Application Ref.: F/4/20/OUT

Proposal: Outline planning application (with all matters reserved except for access) for the development of up to 1,500 dwellings (Use Class C3), 60-bed care home (Use Class C2), up to 9,000 sqm of employment floorspace (Use Classes B1), local centre of up to 2,350 sqm including up to 900 sqm retail/ commercial (Use Classes A1-A5) and 1,450 sqm community/ leisure floorspace (Use Classes D1-D2), land for a two-form entry primary school (Use Class D1), public open space, allotments, new sports pitches and associated facilities, drainage, parking and associated access, infrastructure, landscape, ancillary and site preparation works, including demolition of existing buildings and part removal of existing runway hardstanding.

Location: Land at Ford Airfield Ford

Site Boundary

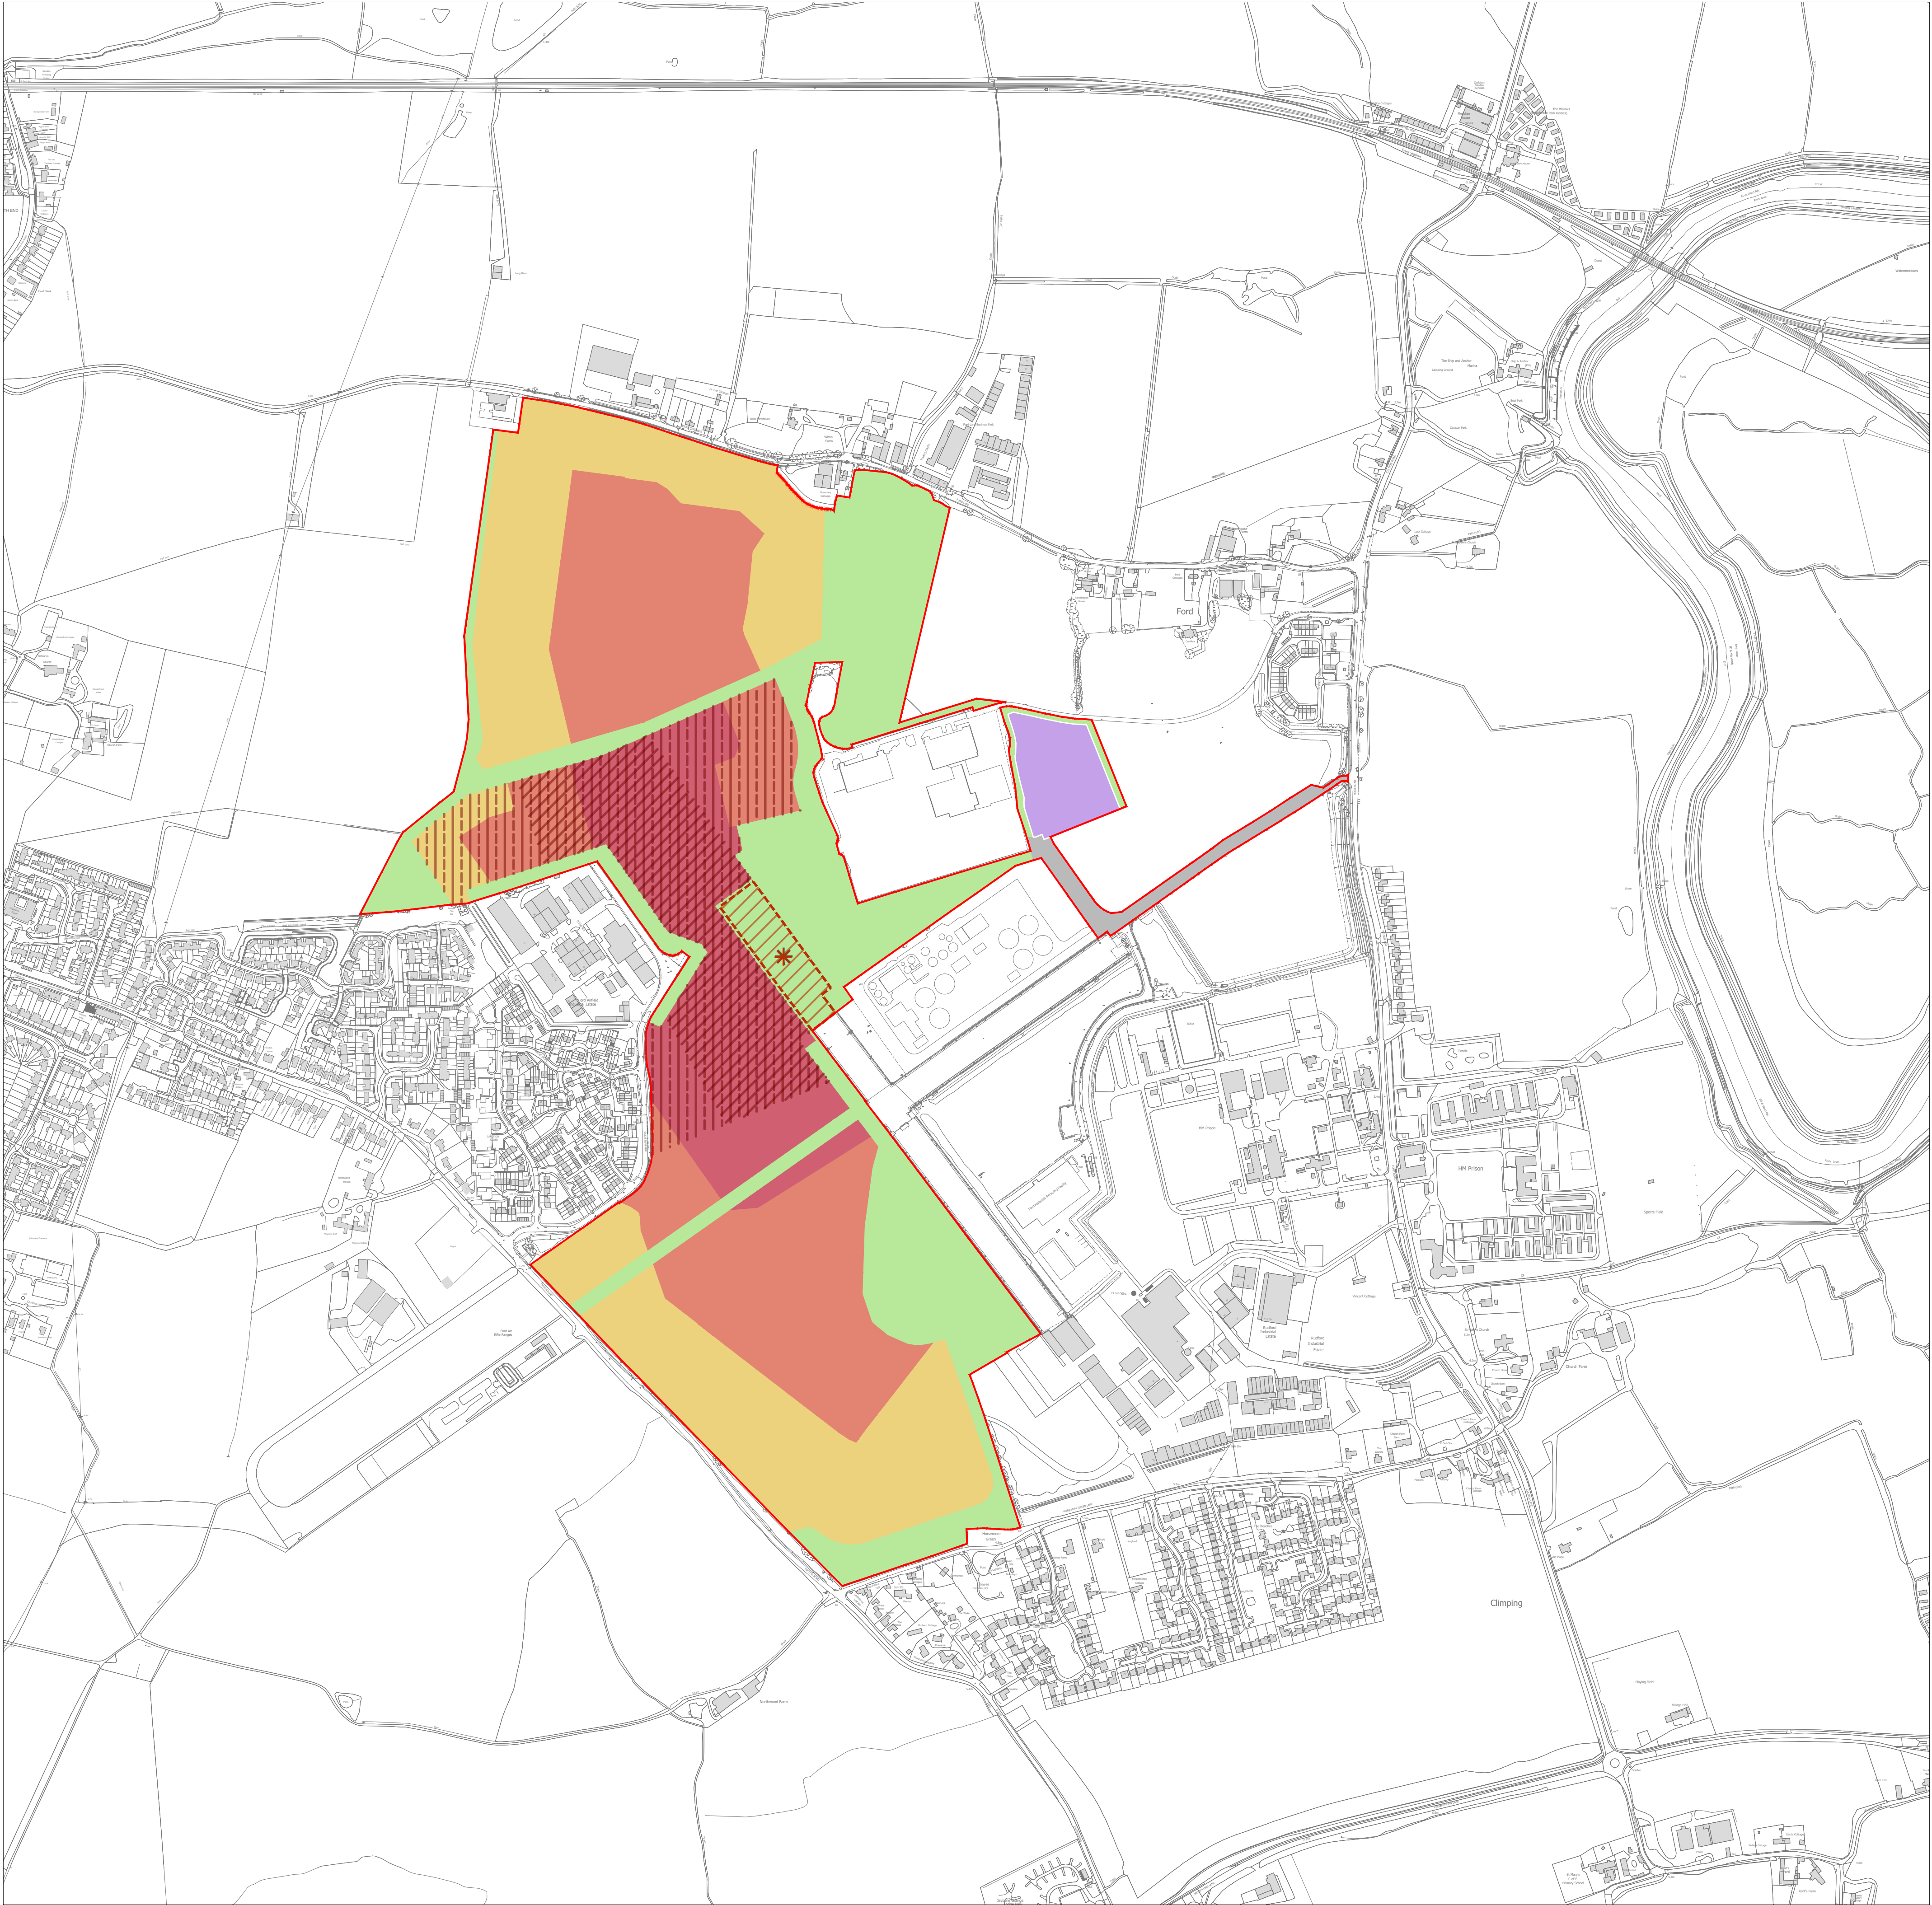
By their very nature, as a result of the types of materials being handled and the operations which take place at waste management facilities, waste management operations have the potential to generate impacts beyond the site boundary. It is for this reason that waste management facilities are typically strategically located a reasonable distance from sensitive receptors, such as residential properties. Suitable sites are therefore very difficult to identify and those that are identified are strongly protected by national policy and local plan policy. The layout proposed in the planning application shown on both the Illustrative Masterplan and the Land Use & Density Parameter Plan (Drawing RG-M-123) is therefore of significant concern.

It is important to note that we do not have any objection to the principle of housing or the employment uses on the Ford Strategic allocation. It is clear to us that an appropriately designed scheme can allow the strategic waste activities to prosper without detriment to future residents. However, it is equally clear that the current scheme has not been appropriately designed or appropriately assessed. We therefore have no option but to **object** to the Land Use & Density Parameter Plan (Drawing RG-M-123) and the proximity and density of the housing and employment uses promoted by the developer.

- The housing layout is reconfigured to provide an optimum distance between sensitive receptors and waste management sites taking into account, noise, odour and air quality and based on realistic assumptions for current, permitted and potential waste activities. As a working assumption the starting position should be a minimum buffer of 250m (consistent with West Sussex County Council's Minerals and Waste Safeguarding Guidance, adopted October 2019).
- Adequate mitigation measures (supported by technical assessments) are built into the scheme to ensure that the risk of complaint is minimised, and the amenity of residents is not compromised.
